Thank you for consulting us regarding the application to discharge condition 10, we have the following comments:

Application No: BE/27/21/DOC
Registered: 23rd February 2021
Site Address: Lidl Great Britain Ltd Land at Phase 1A Oldlands Farm Bognor Regis PO22 9NN
Description of Works: Approval of details reserved by condition imposed under ref BE/126/19/PL relating to Condition No 10 - surface water drainage.

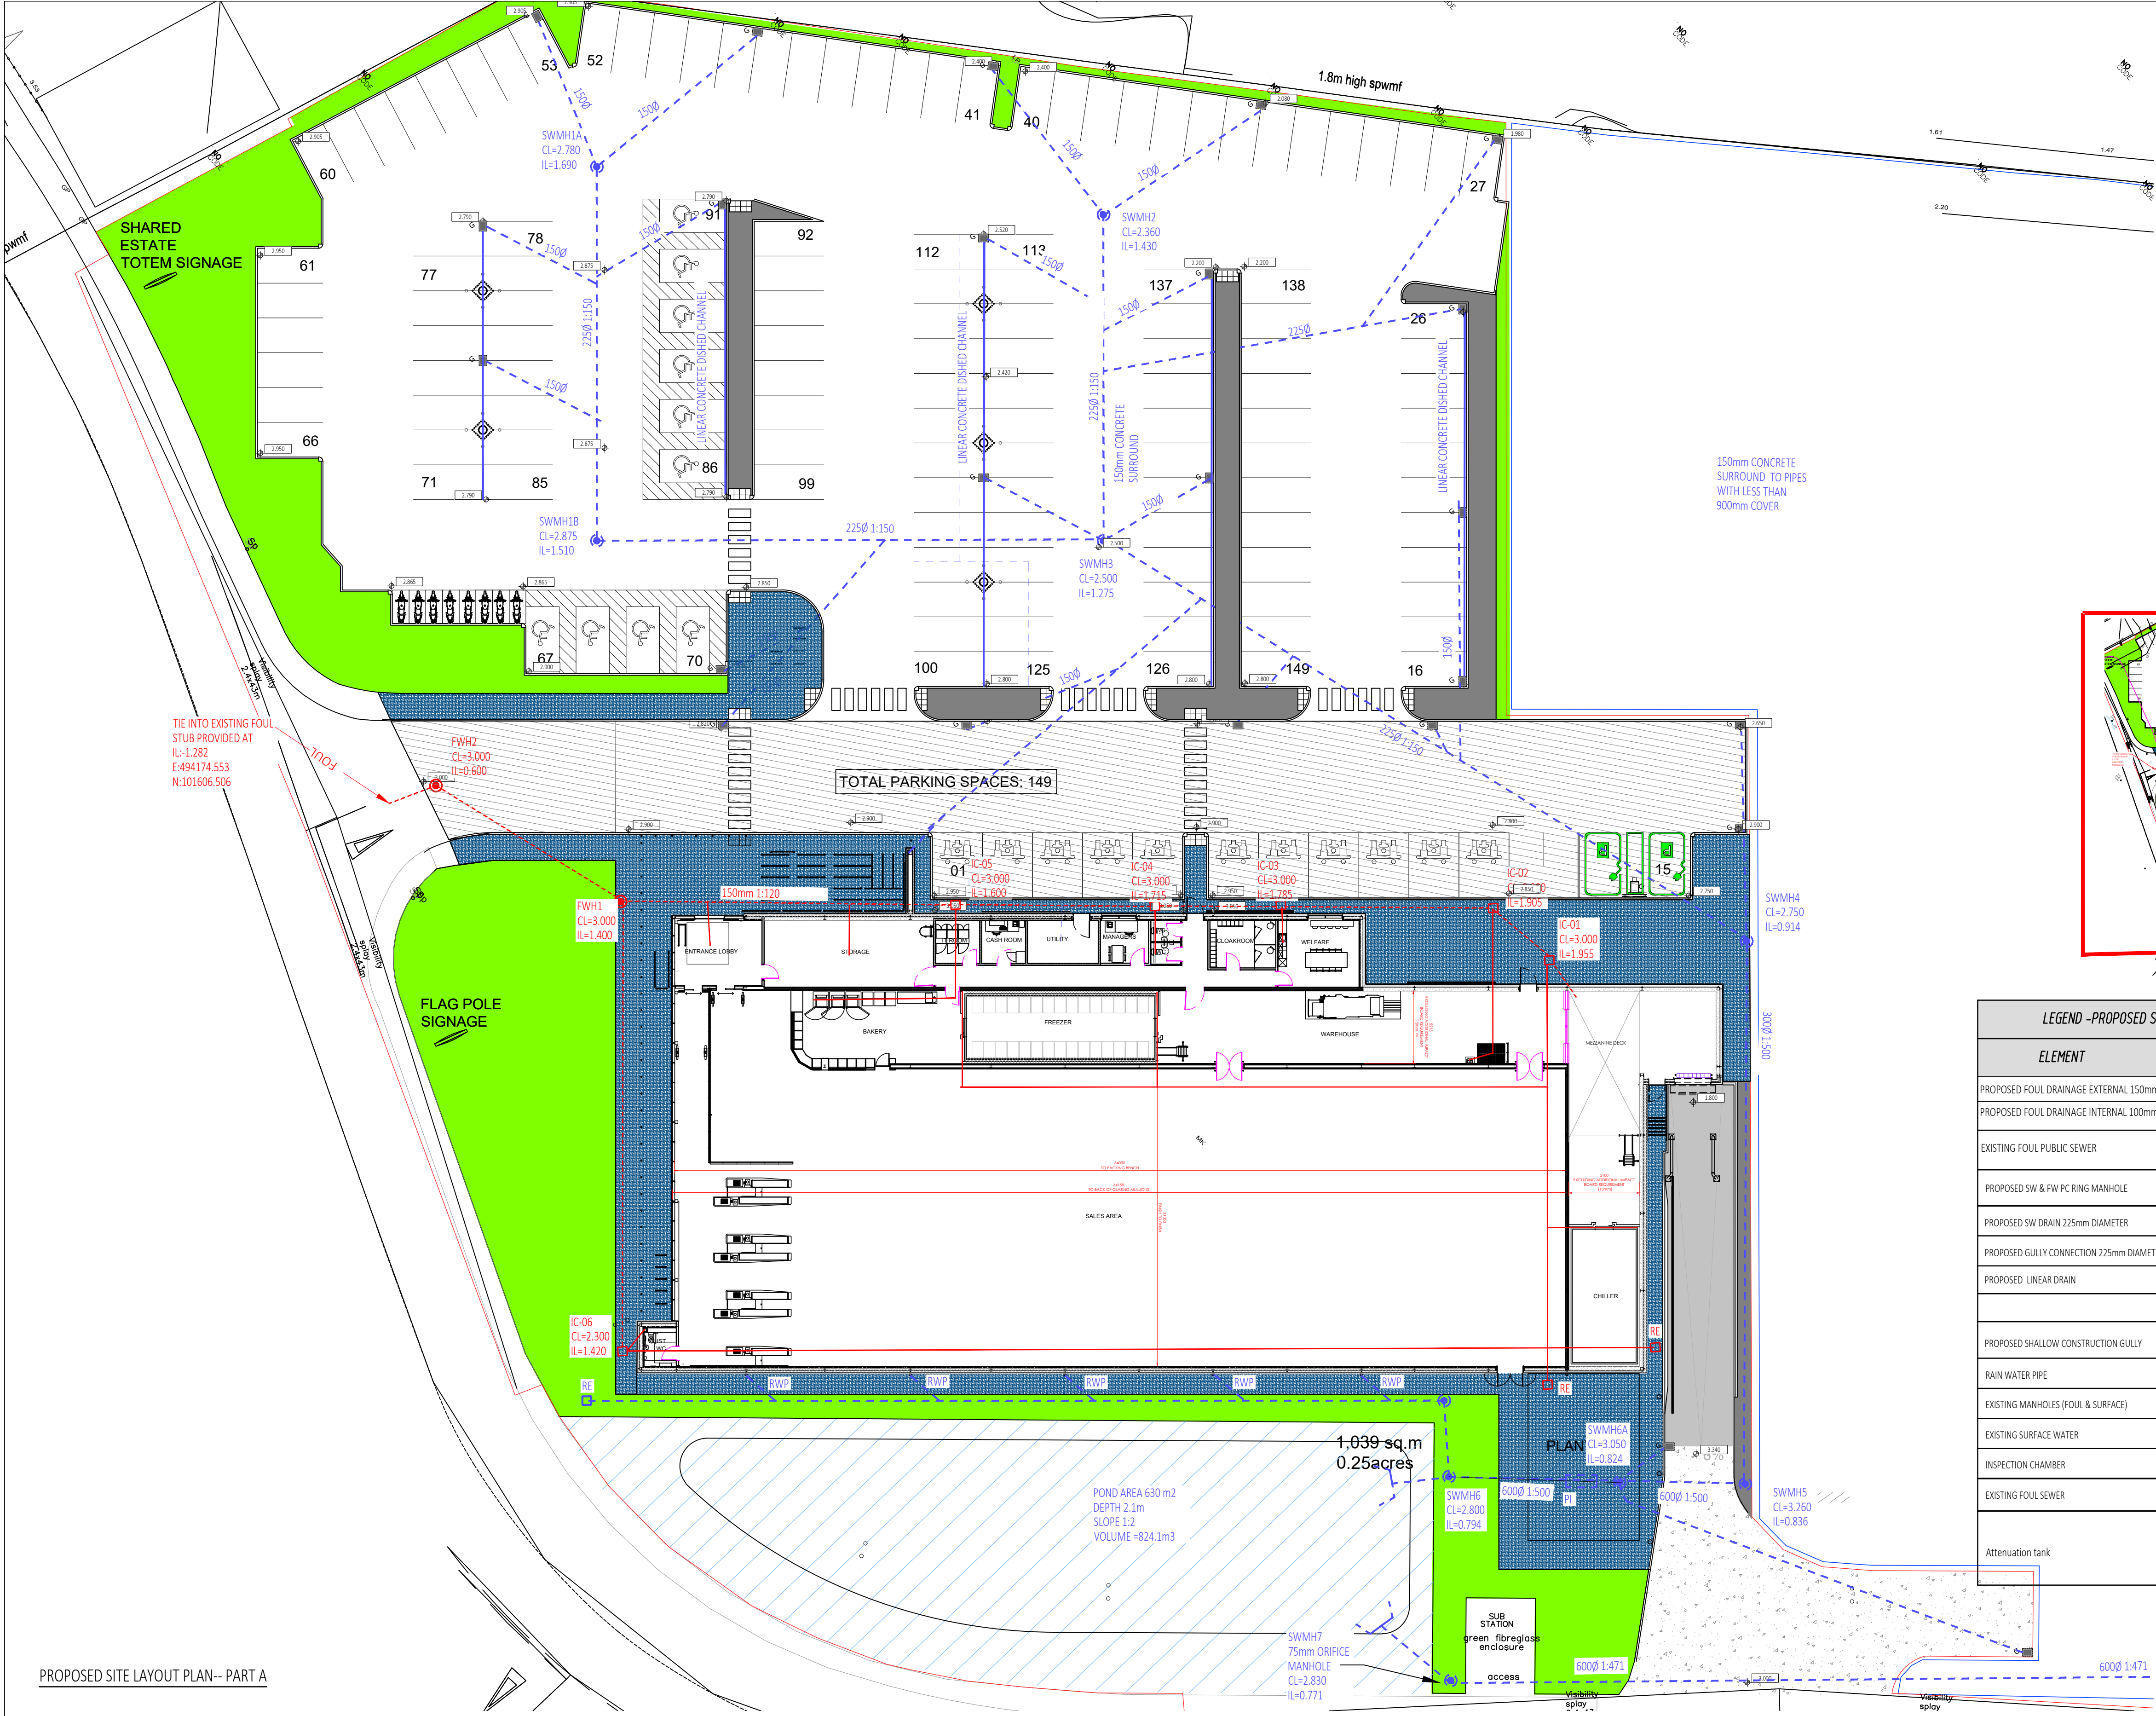
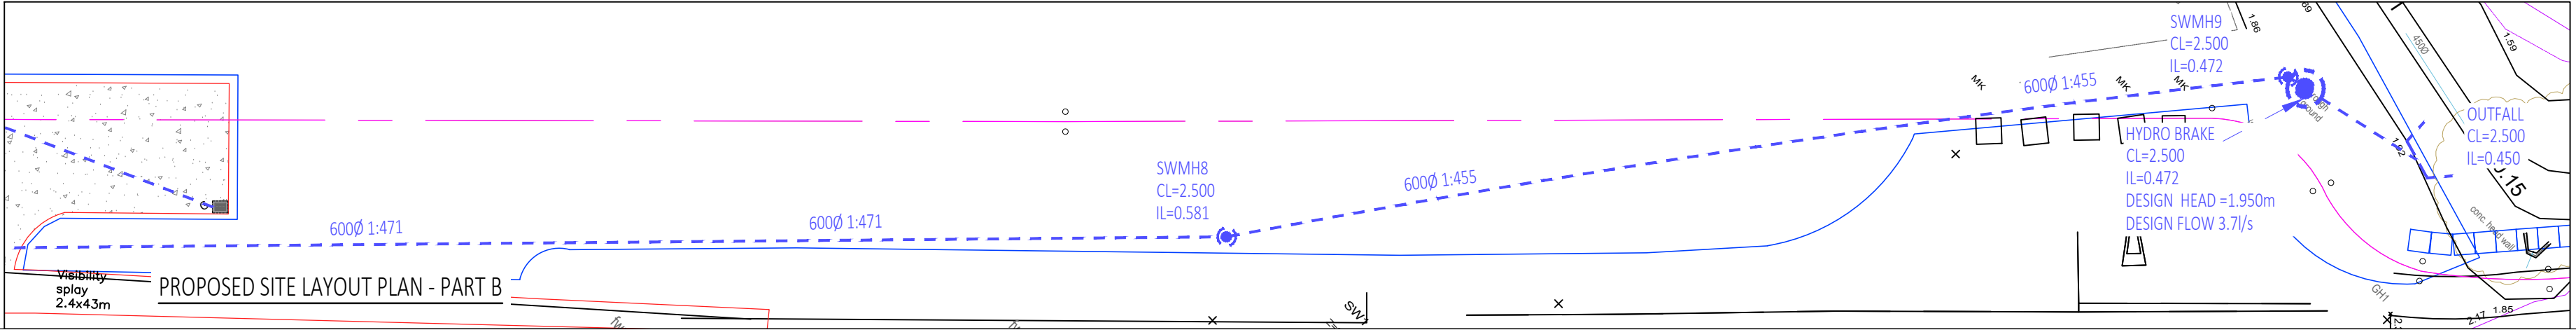
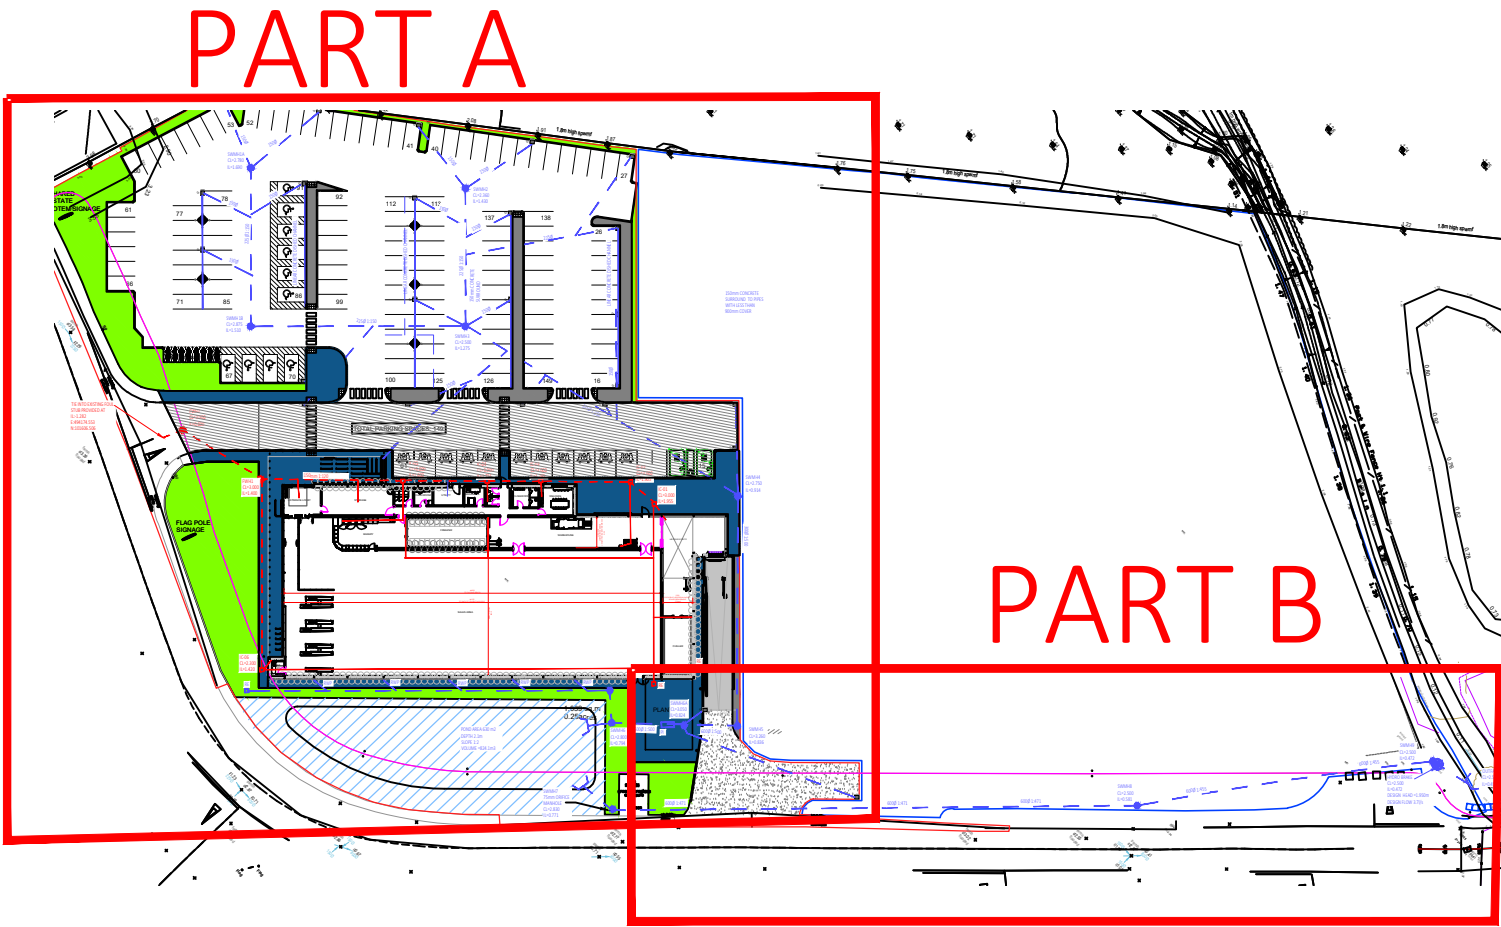
2. The as built survey doesn't include the invert level of the pond. Please include this.
3. There are numerous pipes on the as built drawing which do not include pipe fall or diameter. Please ensure that all pipes are labelled with diameter and fall.

4. There are clearly a number of differences between the approved drawing and what has been constructed. Each of these differences should be discussed by the independent engineer, including an assessment of whether they believe this will affect the functionality of the drainage. Some of these differences are noted below.

- a. The drainage arrangement in the car park is completely different to that designed.
 - b. Pipe diameters at the downstream extent of the car park drainage are significantly less than in the design. I.e. 150 and 225 mm diameter, rather than 300, 450 and 600mm diameter as designed.

- c. The carpark appears to have been constructed significantly lower than that approved, i.e. gulley cover levels 1.98mAOD at lowest, rather than 2.830m as per the drainage design. These cover levels are lower than the water levels in the 30 year return period event.

- d. Linear drainage channels have been installed which were not included in the design. The applicant should submit a revised maintenance manual.
 - e. The pipe between MH4 and 5 is indicated to be 300mm diameter at 1:500 on the as built drawing, the design was for a 600mm diameter pipe at 1:500. The as built drainage does not achieve minimum falls and is likely to cause surcharging and flooding upstream.

5. The differences in as constructed drainage are so significant that we request that updated calculations based upon what has been built are provided. If this demonstrates that the constructed drainage fails to meet policy requirements then alterations will have to be agreed and made on site.
